## **Blue Mountains Conservation Society Inc**

Great Western Highway Upgrade  
Blackheath to Little Hartley – EIS Submission  
PO Box 334  
PARKES NSW 2870

#### **Great Western Highway Upgrade: Blackheath to Little Hartley EIS (SSI-22004371)**

Figure 12-7 Distribution of groundwater dependent ecosystems within the assessment area at Blackheath

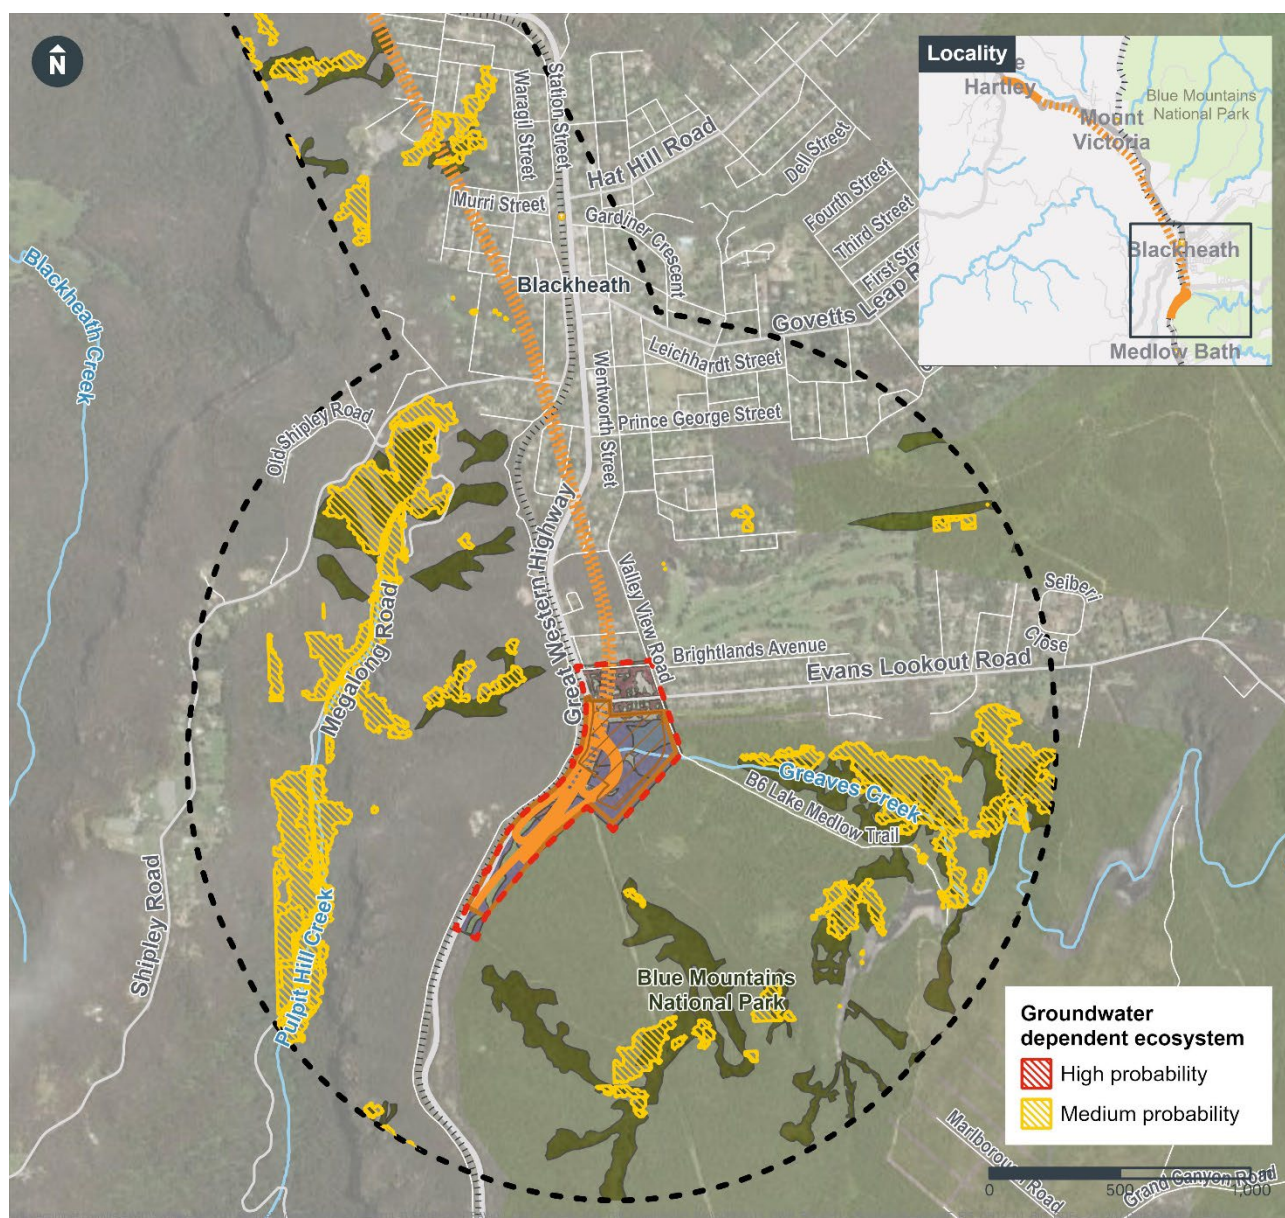
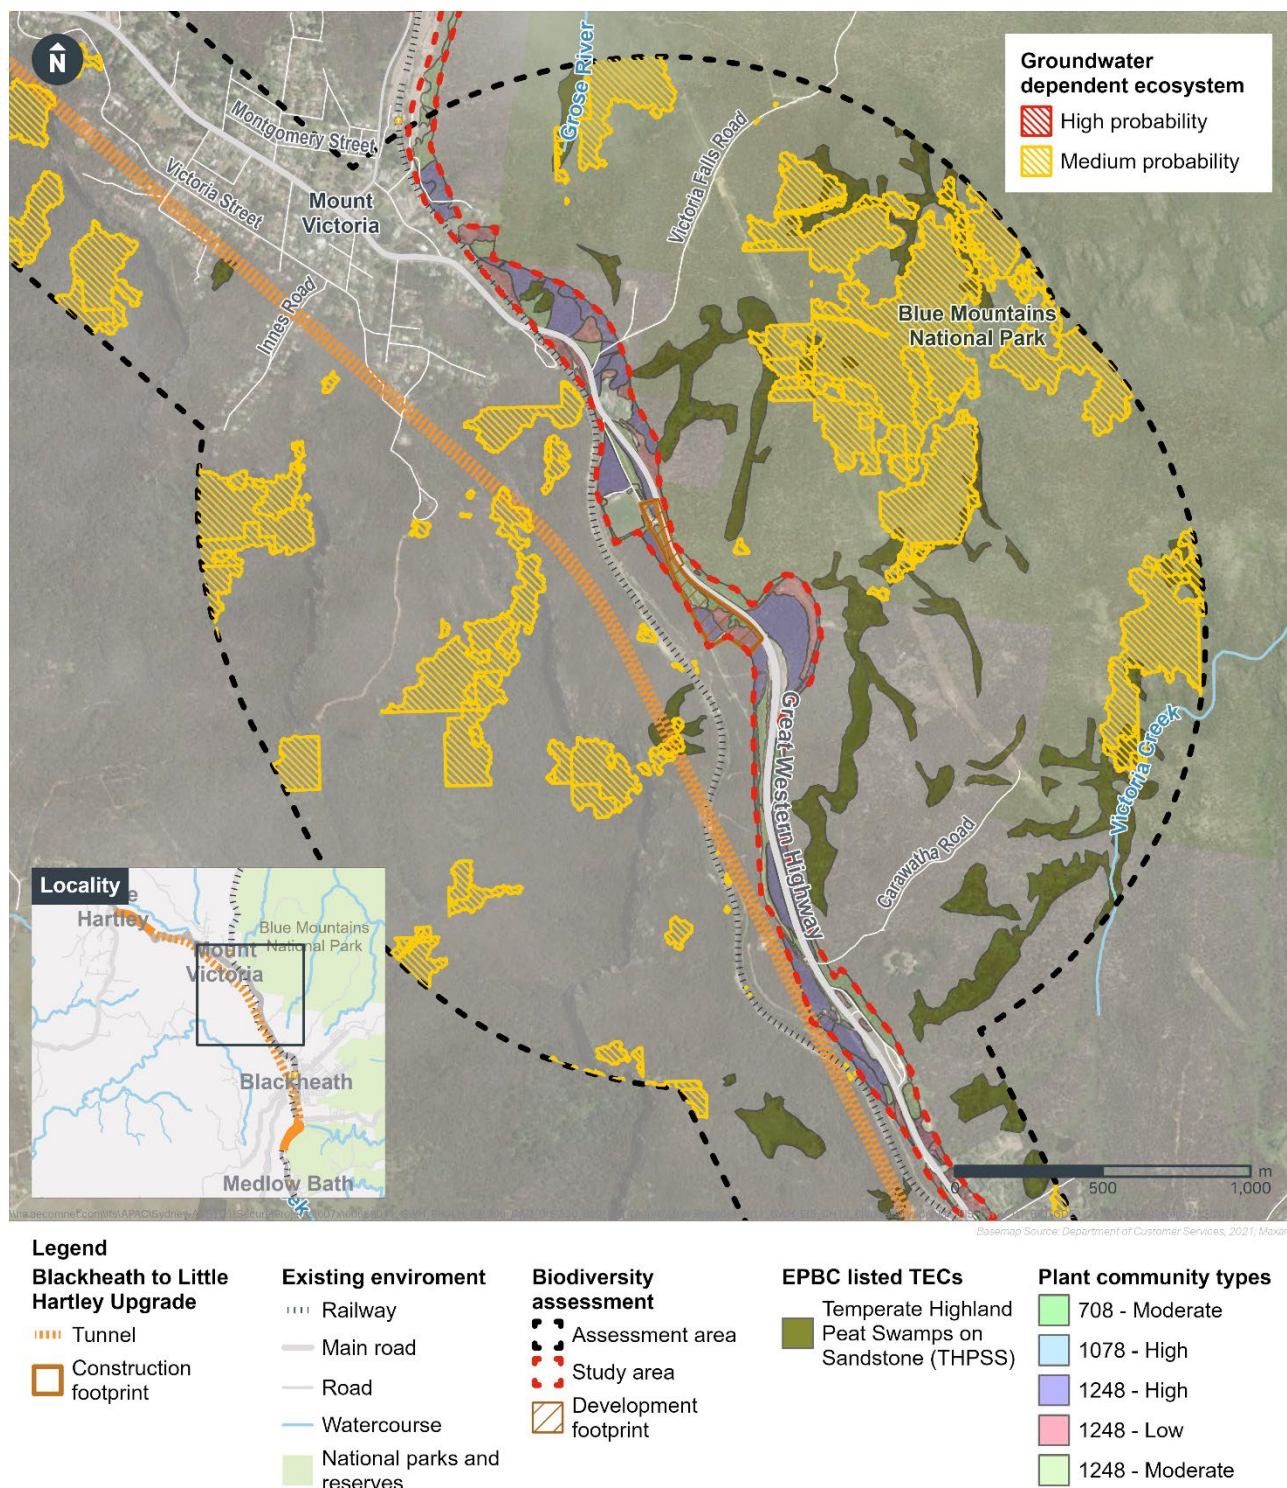
It is likely that water flow changes resulting from project construction will have a direct impact on threatened species. About half the ground-dependent ecosystems shown within the 1500m buffer zone assessment areas (the black dashed circle on the EIS maps for Blackheath and Soldiers Pinch, Figures 12.7 and 12.8), are to the east of the GWH and are within the Blue Mountains National Park, and all are THPSS, which are EPBC nationally-listed swamps. Although the EIS shows most of these swamps as medium probability GDE, there is no consideration in the EIS for THPSS located further downstream along the Greaves Creek catchment area into the WHA area and in the popular Grand Canyon hiking area region, nor further downstream into the WHA from the Soldiers Pinch 1500m buffer zone.
